COMPREHENSIVE OBJECTION TO AMENDED STATE SIGNIFICANT DEVELOPMENT APPLICATION

**SSD-83478456 — Residential Development with In-fill Affordable Housing
21, 23 and 25 McIntosh Street and 55 Werona Avenue, Gordon**

Date: 9 June 2026

Submitter: Owner of 12 Forsyth Street, Killara/Gordon (this submission updates earlier submission ref: SUB-92392706).

DA50.64

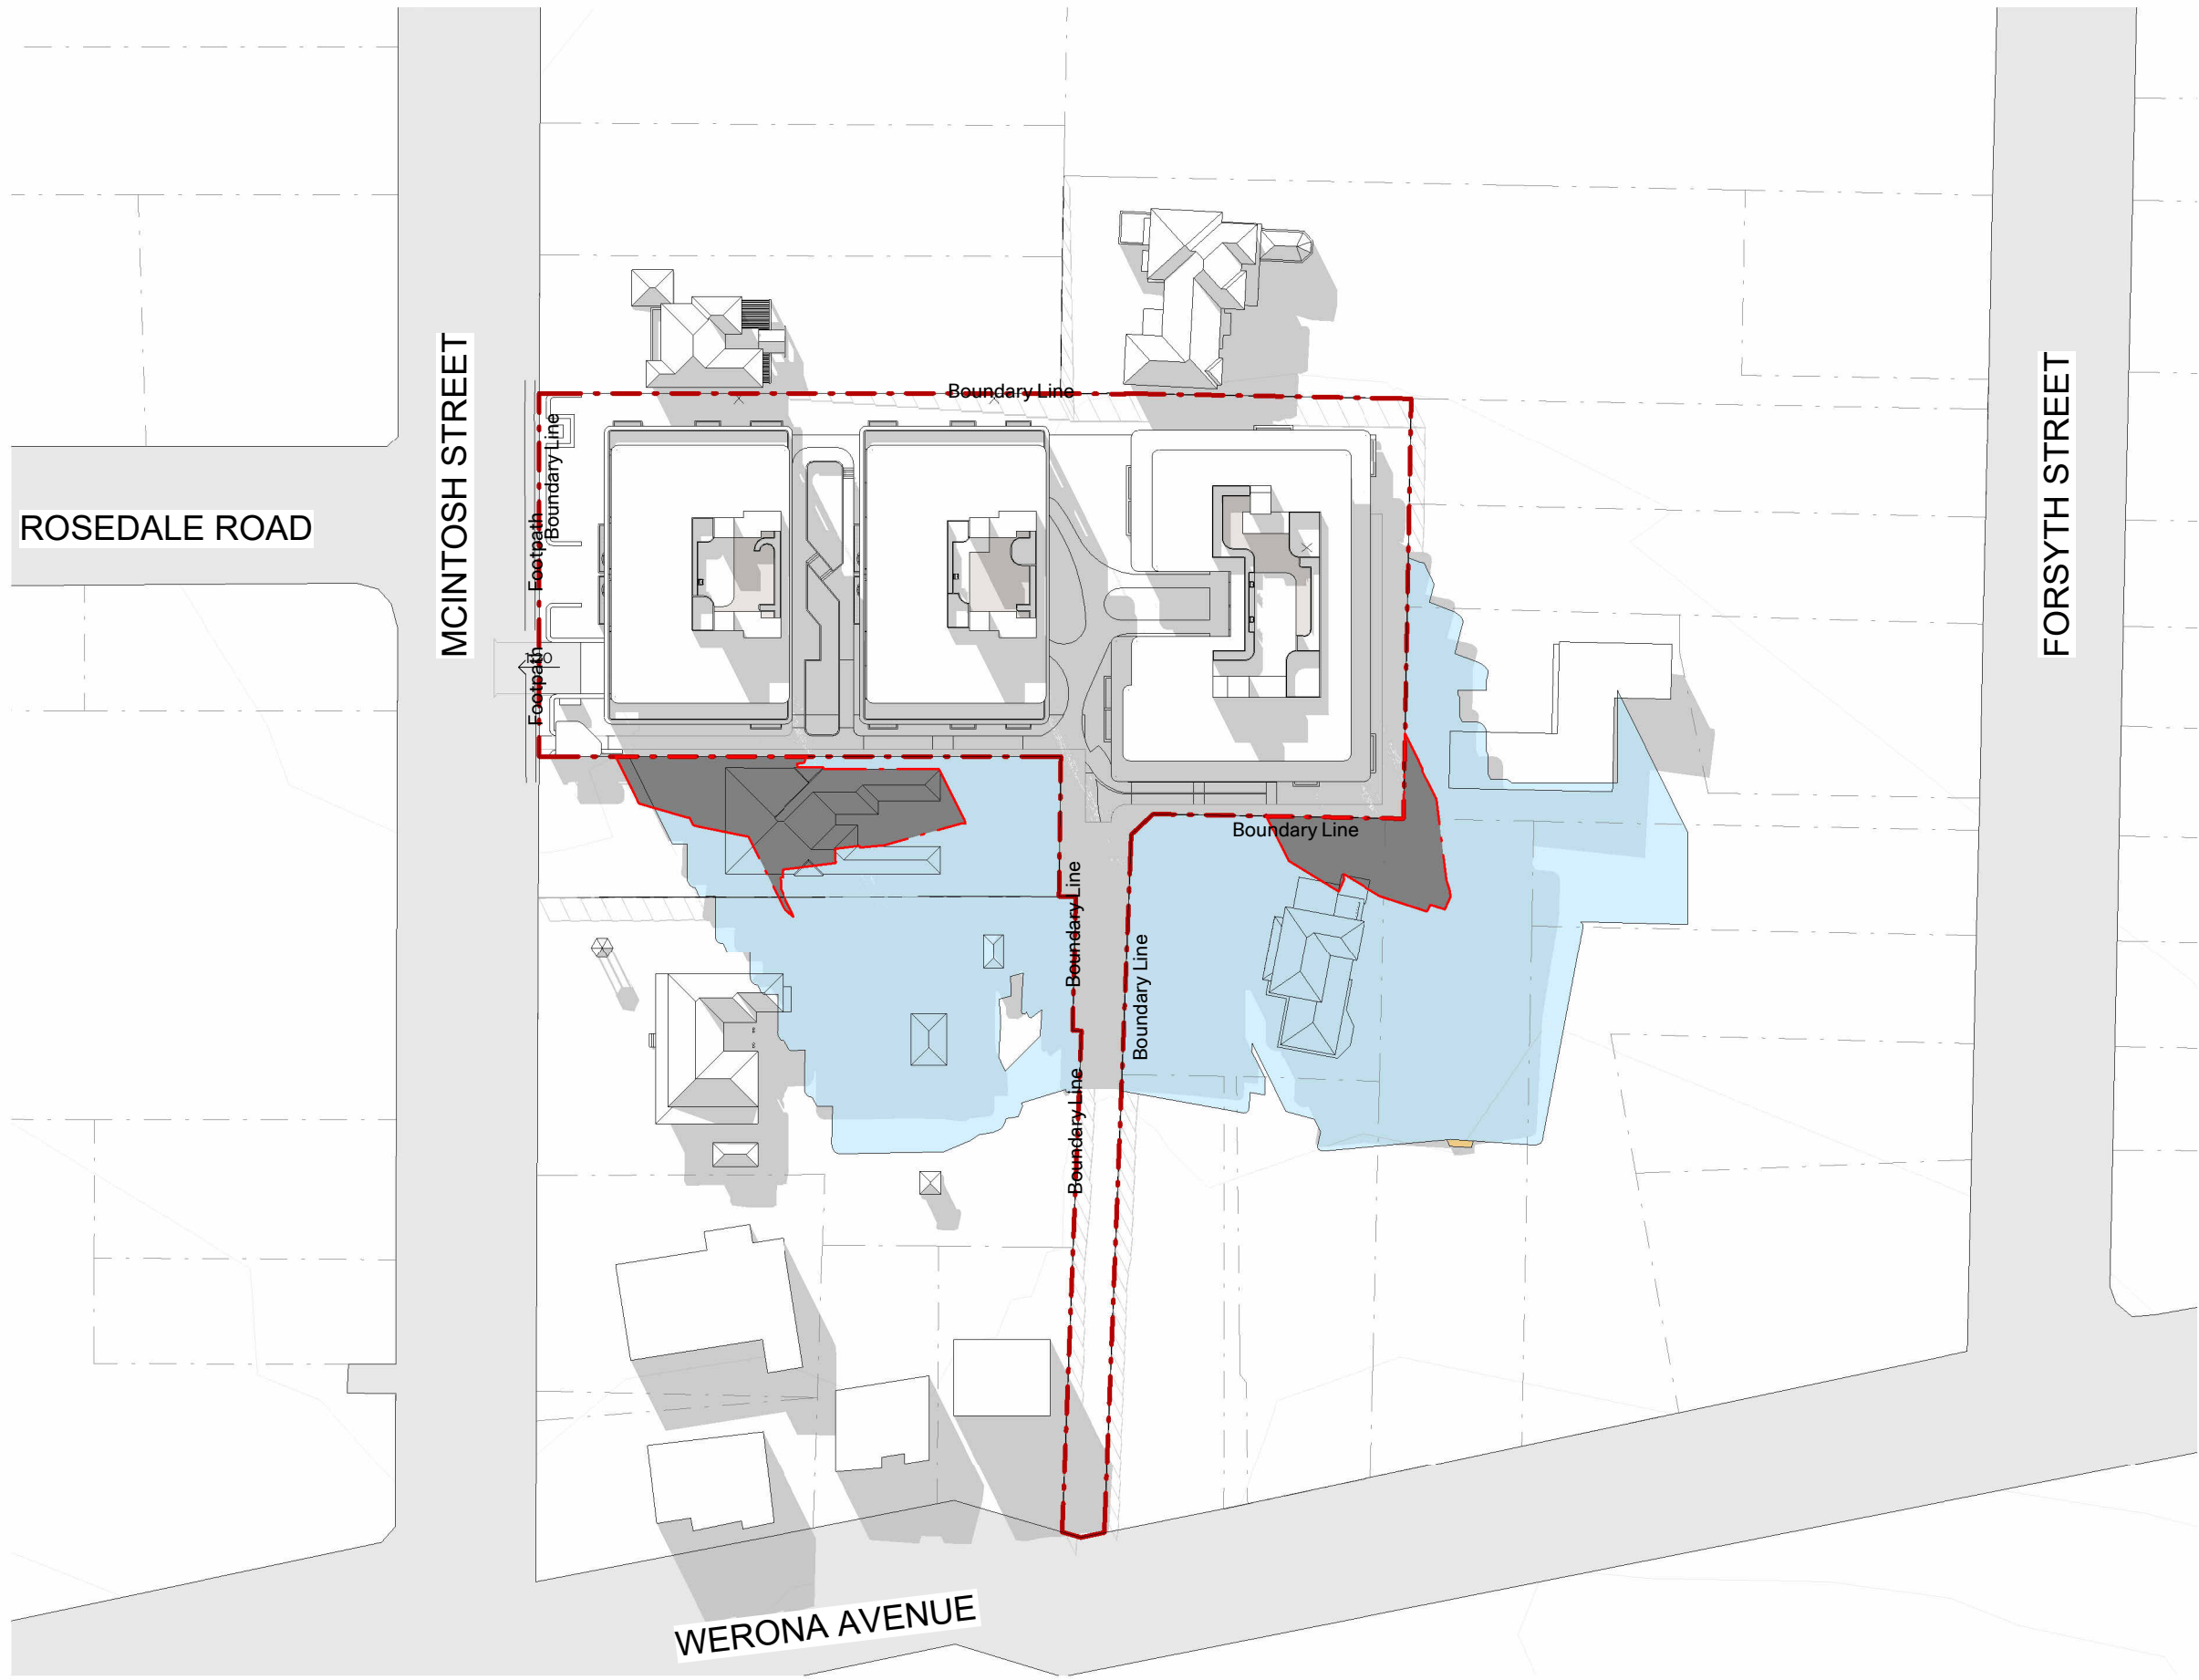
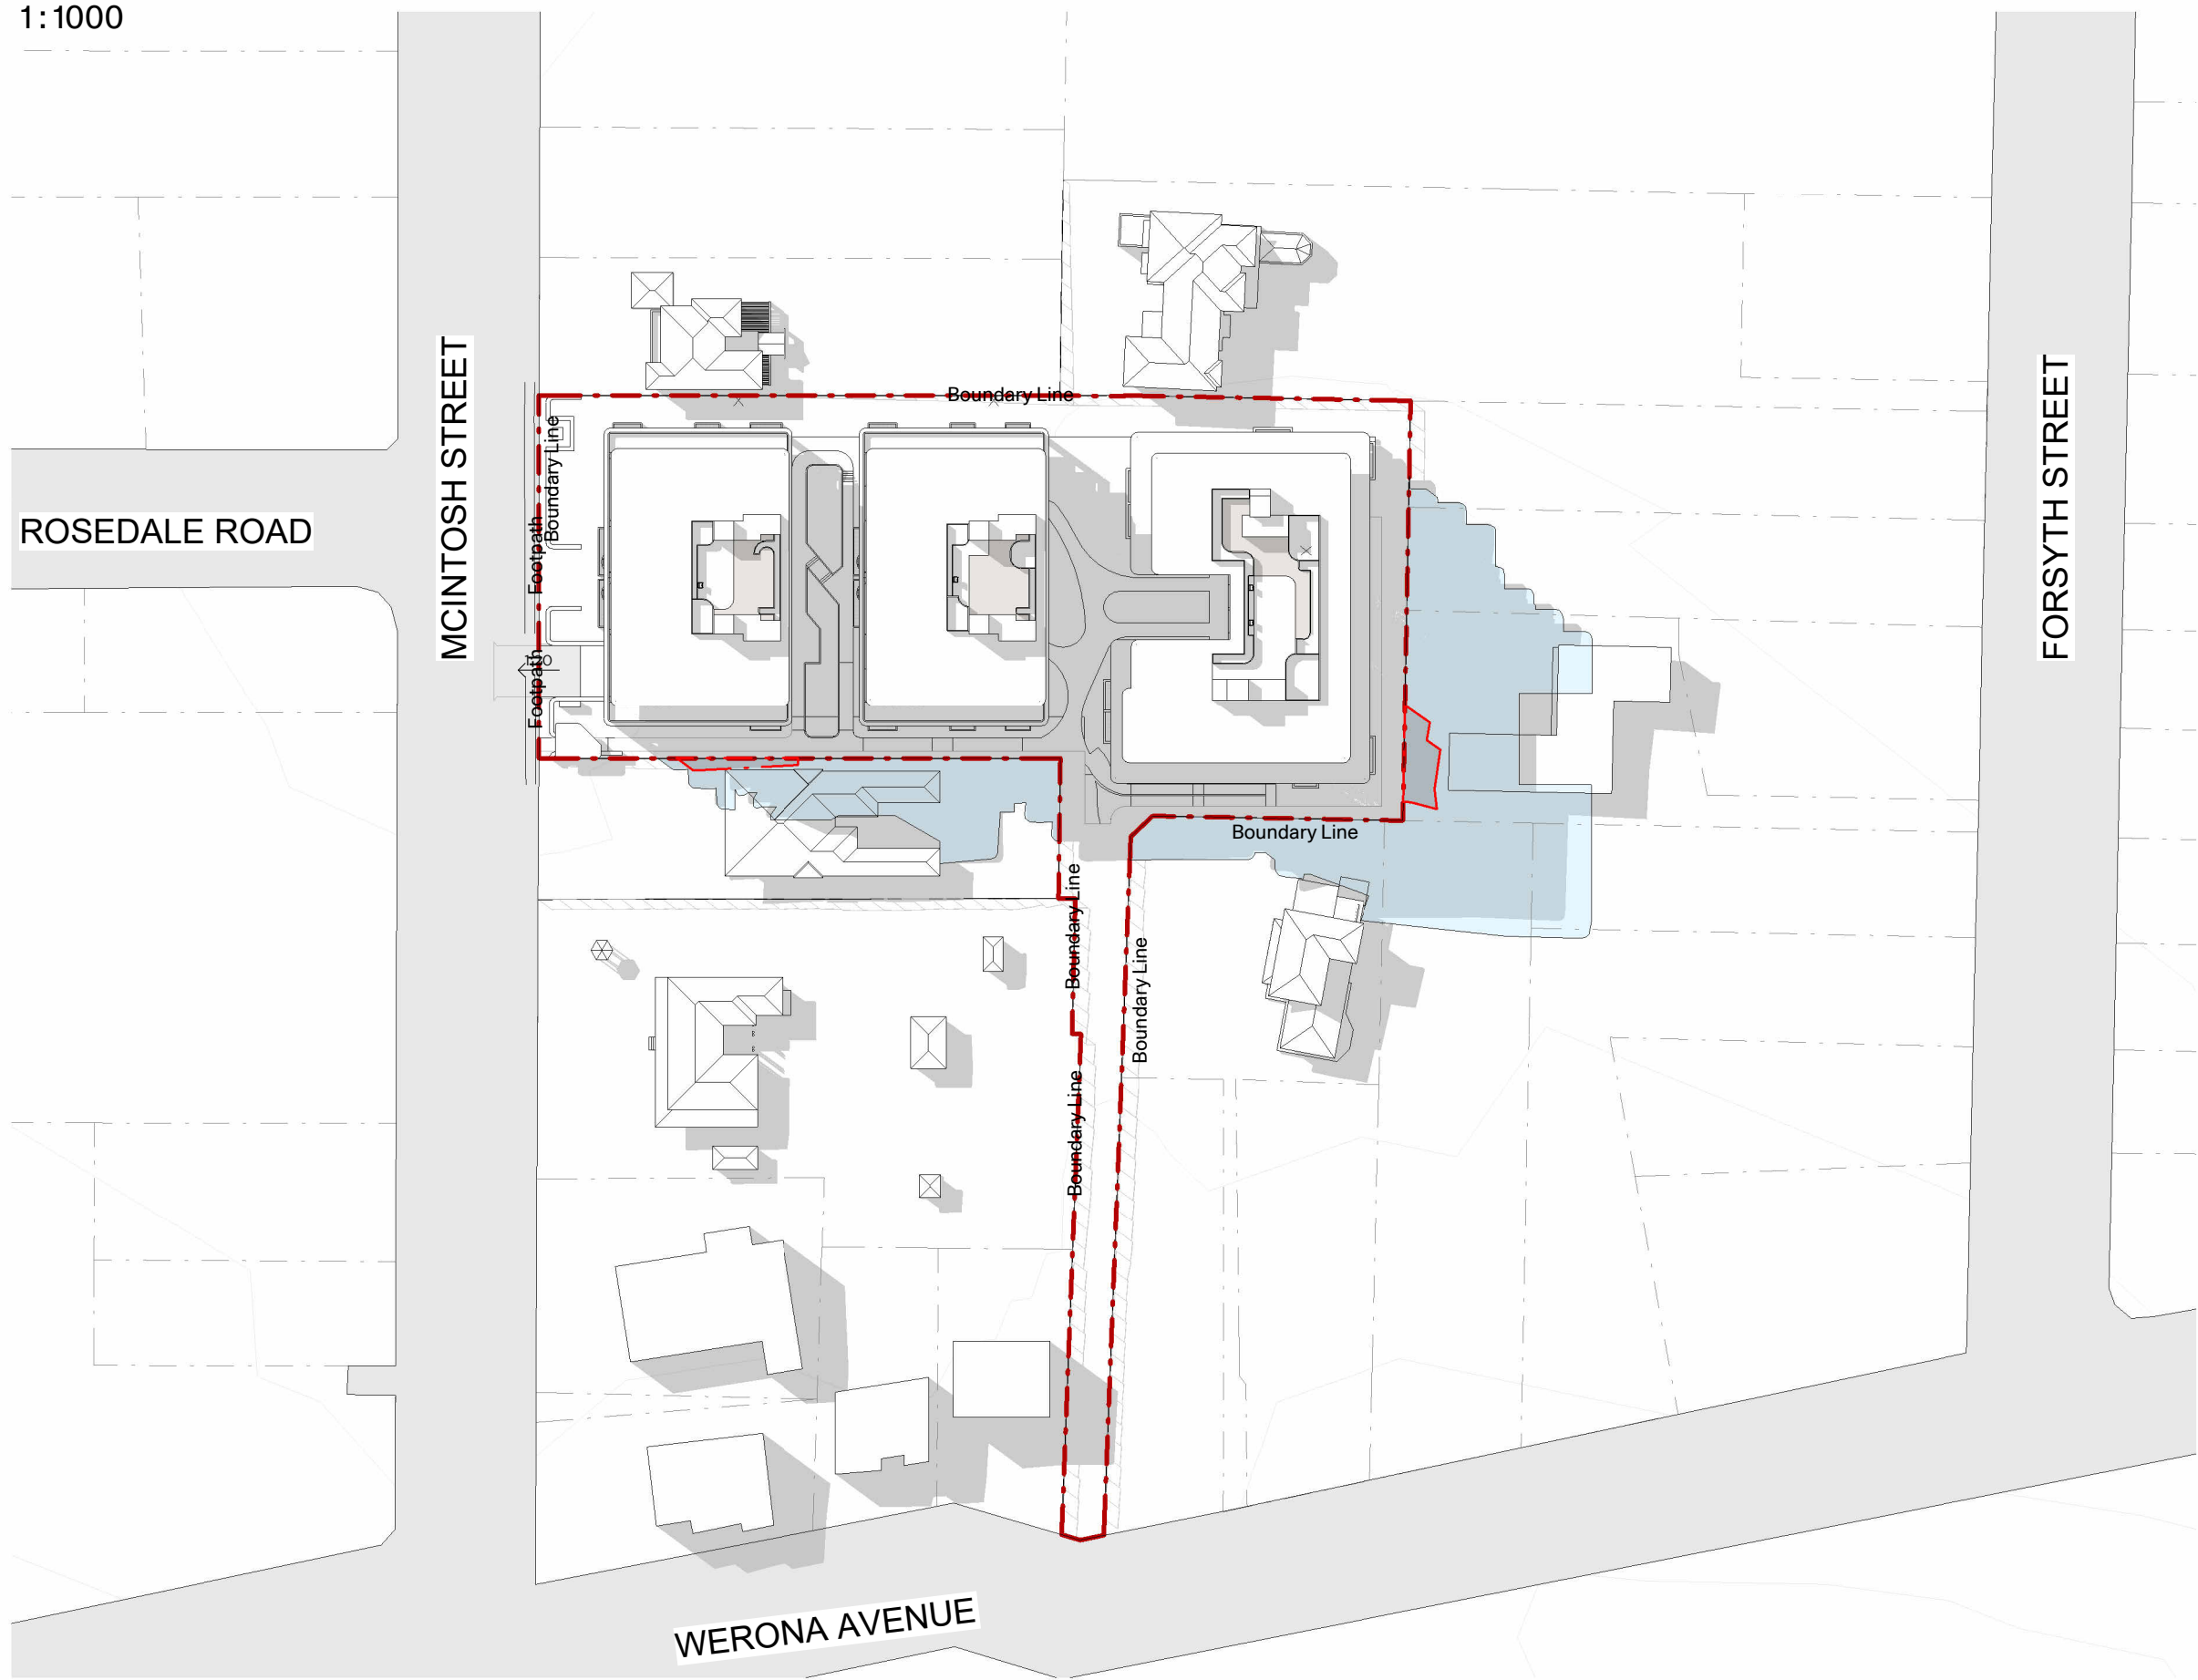
This is the central direct impact on my property. The applicant's own Amendment Report states that 12 Forsyth Street experiences additional overshadowing from the proposed development, that not all parts of the dwelling receive two hours of direct sunlight between 9am and 3pm on 21 June, and that only one primary frontage and a nominated 25 sqm private open space area receive some solar access — while acknowledging this does not fully satisfy the prescriptive controls. The report concedes the proposal does not achieve full compliance with the solar access controls for 12 Forsyth Street in its current form.

This is not a matter of subjective neighbour preference. It is a direct admission that my dwelling is adversely affected. The applicant characterises the impact as “minor” or “partial”; that characterisation should be rejected and the shadow analysis independently verified against my approved two-storey plans. I note the applicant's Stormwater Plans (Appendix P) still describe my property as a “Single Storey Brick Residence Under Construction,” while the architectural plans treat it as two-storey — the shadow and amenity baseline is internally inconsistent and unreliable.

The Department should require the applicant to redesign Building C to remove the non-compliant solar impact — reducing Building C, removing or relocating Level 8 / rooftop communal open space, increasing the southern setback, and providing verified, plan-based shadow diagrams for the actual approved dwelling, living areas, windows and principal private open space at 12 Forsyth Street.
